Wylfa Newydd Local Impact Report

Chapter 13: Air Quality

December 2018

PINS Ref: EN010007

Figure 1 Mainland Wales road traffic emissions study area, monitoring and receptors locations

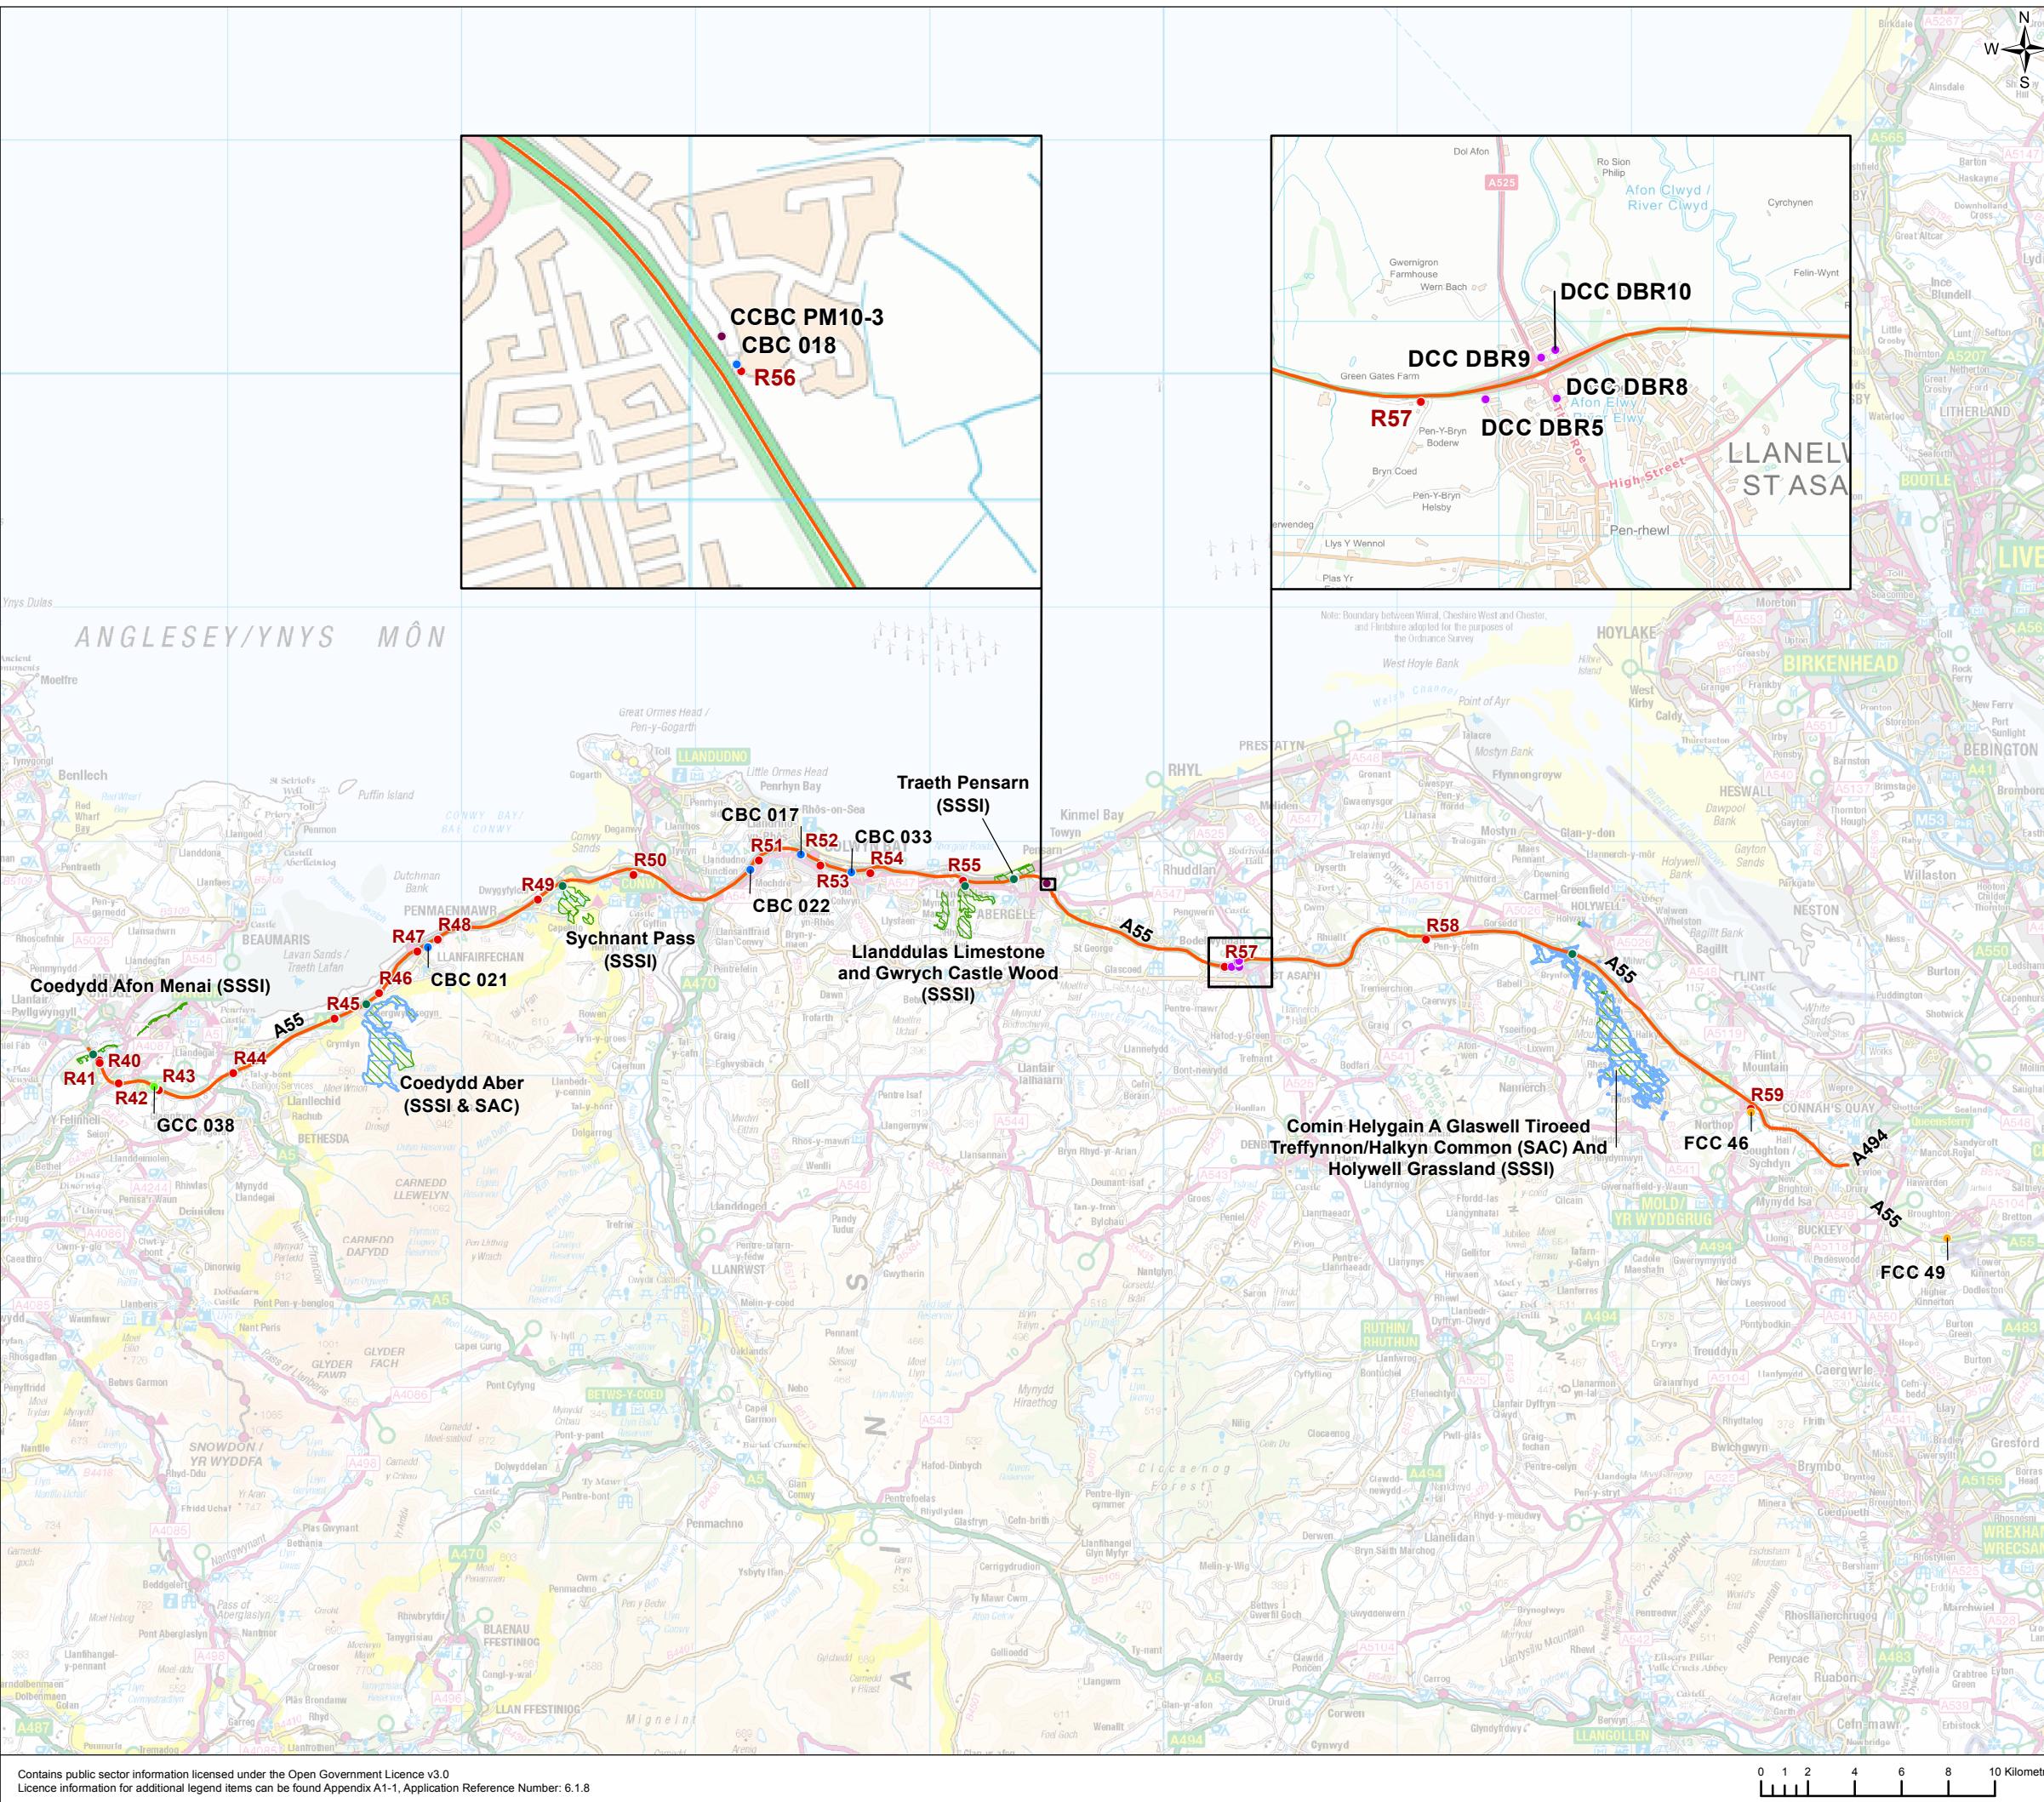
- 2.15 As confirmed in ES Volume C4 Air Quality effects of traffic, the IACC has measured annual mean NO₂ concentrations of 39.7 $\mu\text{g}/\text{m}^3$ at a layby off the A55 at Llanfair Pwllgwyngyll in 2016 (close to receptor R36). The predicted future baseline concentration at the edge of the layby closest to the A55 carriageway in 2020 is 39.4 $\mu\text{g}/\text{m}^3$, and this is predicted to increase to 40.8 $\mu\text{g}/\text{m}^3$ due to the Wylfa Newydd Project road traffic emissions (R36). Horizon's Assessment states that these values are considerably lower than the empirically derived value of 60 $\mu\text{g}/\text{m}^3$ and have therefore concluded that an exceedance of the one-hour mean AQO is very unlikely.

- 2.16 IACC is requesting that Horizon commits to the installation of monitoring systems at the layby location (monitoring location A15) to allow the one hour mean AQO for NO₂ be monitored in real-time for exceedances as a result of additional traffic. The IACC will use these monitoring results in considering whether measures need to be implemented in this location as part of its ongoing air quality responsibilities. The IACC proposes that this monitoring is undertaken by AQ Mesh type of monitoring device. Such monitoring data can be made available in near-real time. Diffusion tubes, providing a robust measure of monthly means, should be collocated with the AQ Meshes.

- 2.17 Horizon's air quality assessments also confirm that measurements undertaken at a layby location very close to the kerbside of the A55 (east bound carriageway) to the southeast of the Britannia Bridge indicate that annual mean concentrations

could exceed 60 $\mu\text{g}/\text{m}^3$ (ES Vol.C)²⁹. On this basis, there is the possibility that the one-hour mean AQO value of 200 $\mu\text{g}/\text{m}^3$ could be exceeded more than the permitted 18 times in the year at this short-term exposure location. The ES confirms that a further consultation meeting with Gwynedd Council is planned to review the full monitoring dataset once 12 months of data have been recorded and to agree further monitoring and assessment work. The IACC would wish to ensure that the monitoring proposals for each layby location is consistent including use of monitoring equipment and requires confirmation of the details.
